Planning Application: Seeking advice on a planning application for the erection of 1 No. dwelling and separate single storey double garage.

Reference: BN/19/18/PL

Location: The Cottage Piggeries, Church Lane, Barnham

Diagram - Location of Existing Trees & Hedges, all to be retained

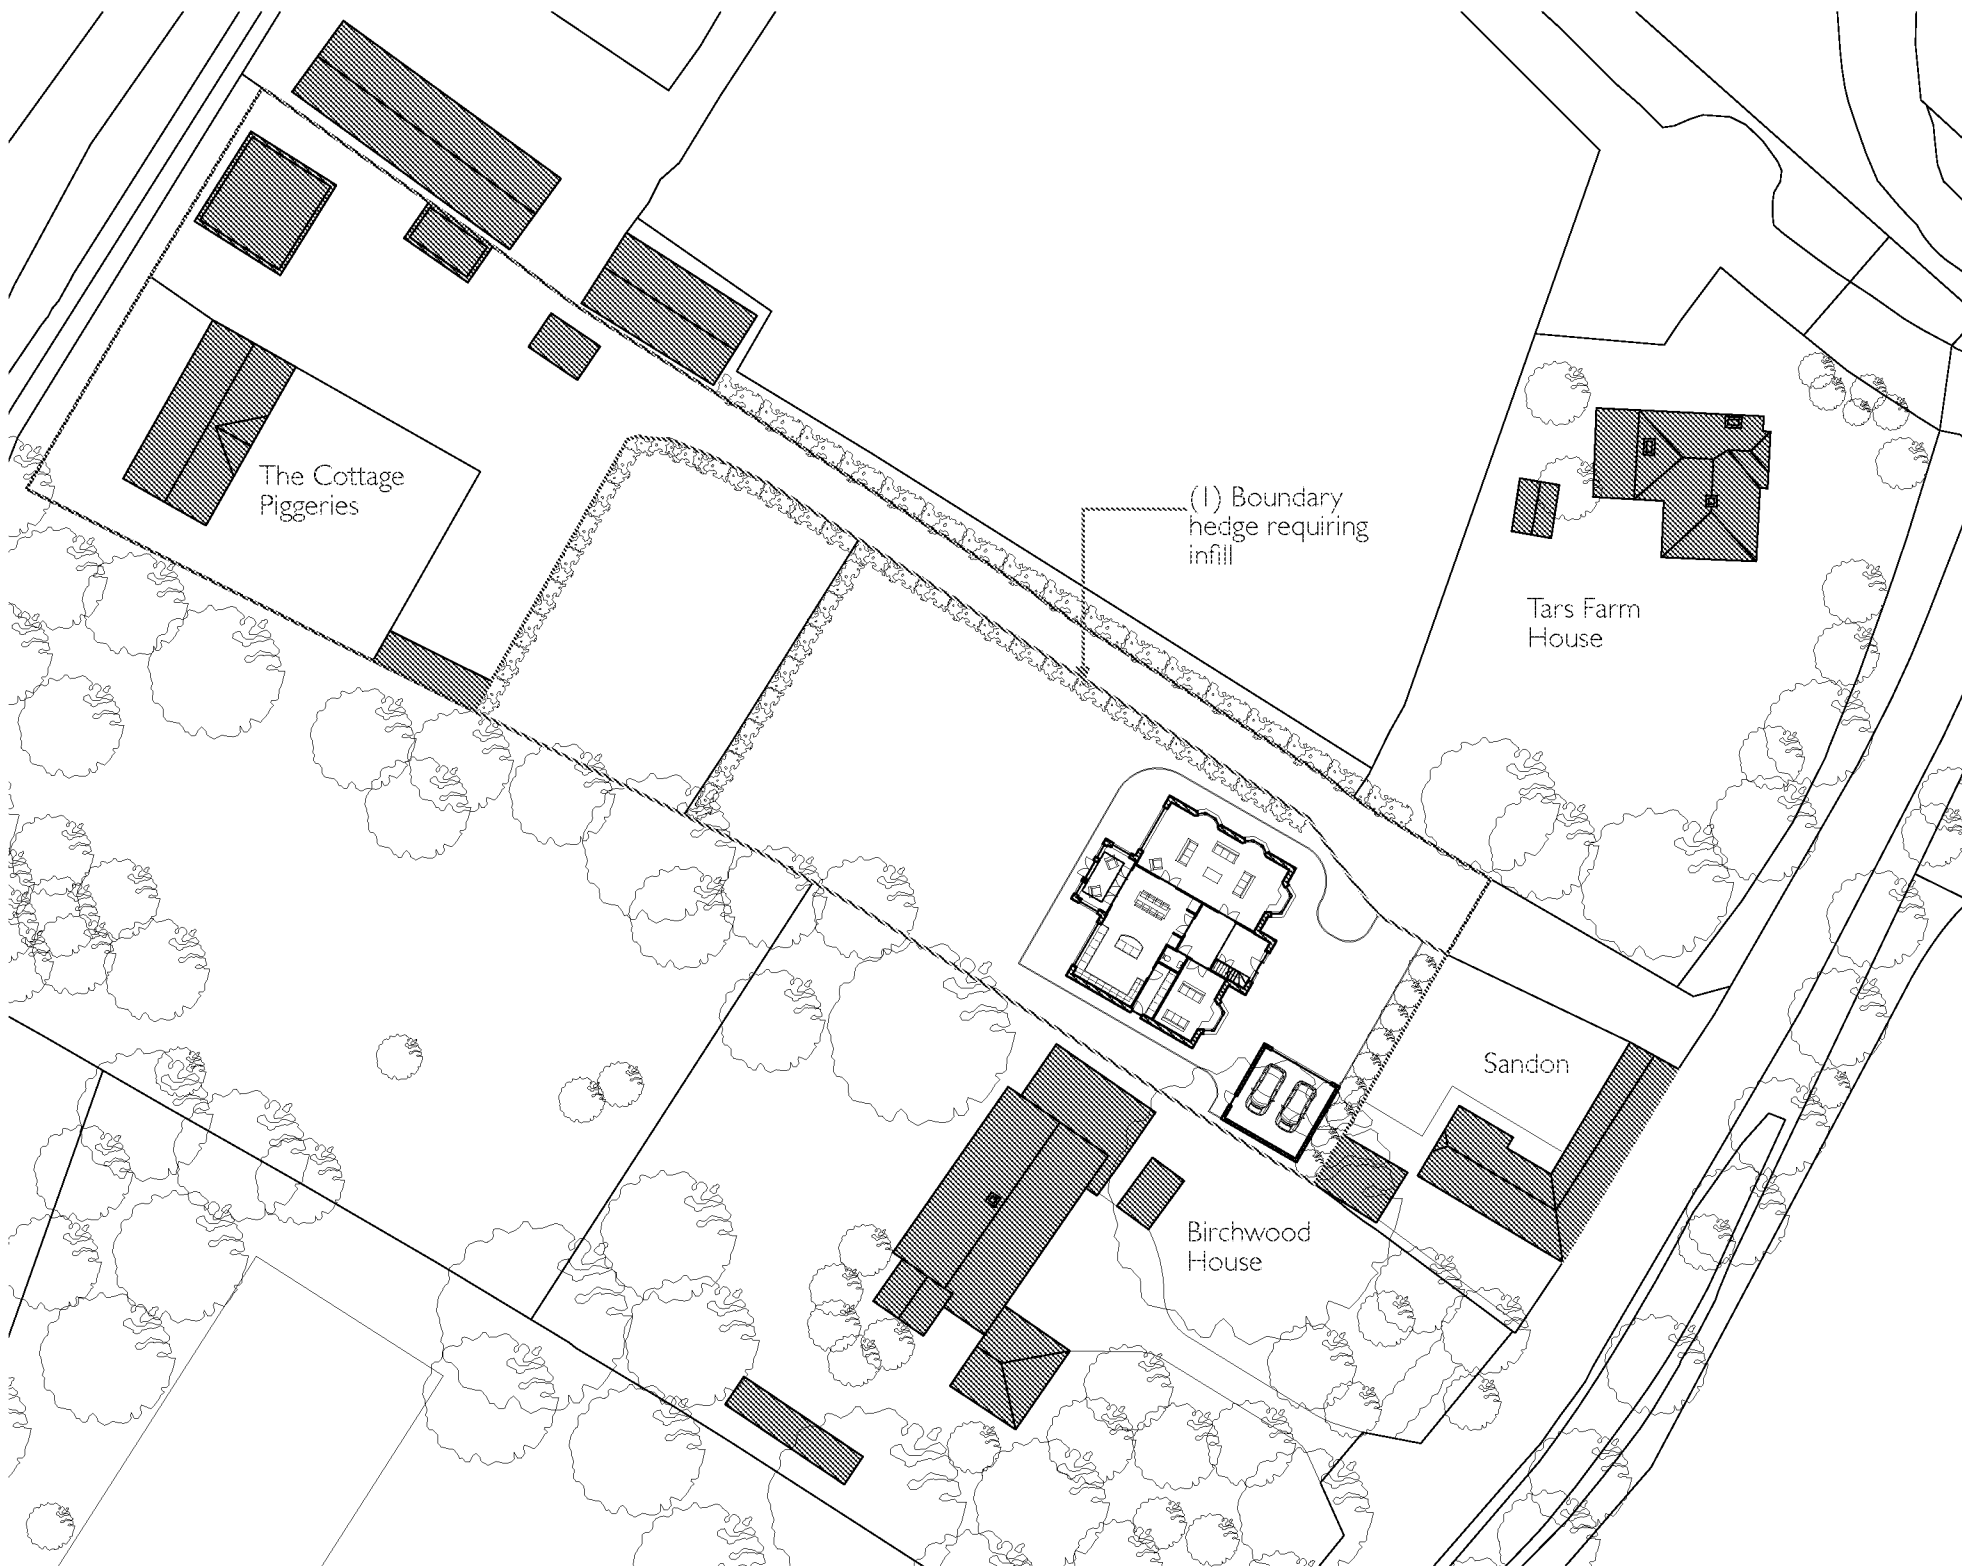
- The applicants have in their Planning Application stated at Section 15 Trees and Hedges that there are no trees on land adjacent to the site that might be affected by these proposals. This is clearly a false statement as I noted a very fine mature Pine tree in the neighbouring front garden of Birchwood House and a further two Pines further down their rear garden that would in my opinion be impacted by these proposals.

- No supporting arboricultural information has been submitted with this application despite the fact that there is a mature Monterey Pine tree in the adjacent front garden of Birchwood House whose Root Protection Area will be compromised by the proposals plus a further two trees in the rear garden that may also be impacted.

- The applicants will need to supply an **Arboricultural Method Statement & Tree Protection Plan** in support of their application with full details of how they plan to mitigate the potential harmful impact on the roots of the neighbours trees.
- I register an **OBJECTION** on the grounds that no supporting arboricultural information has been submitted with this application.
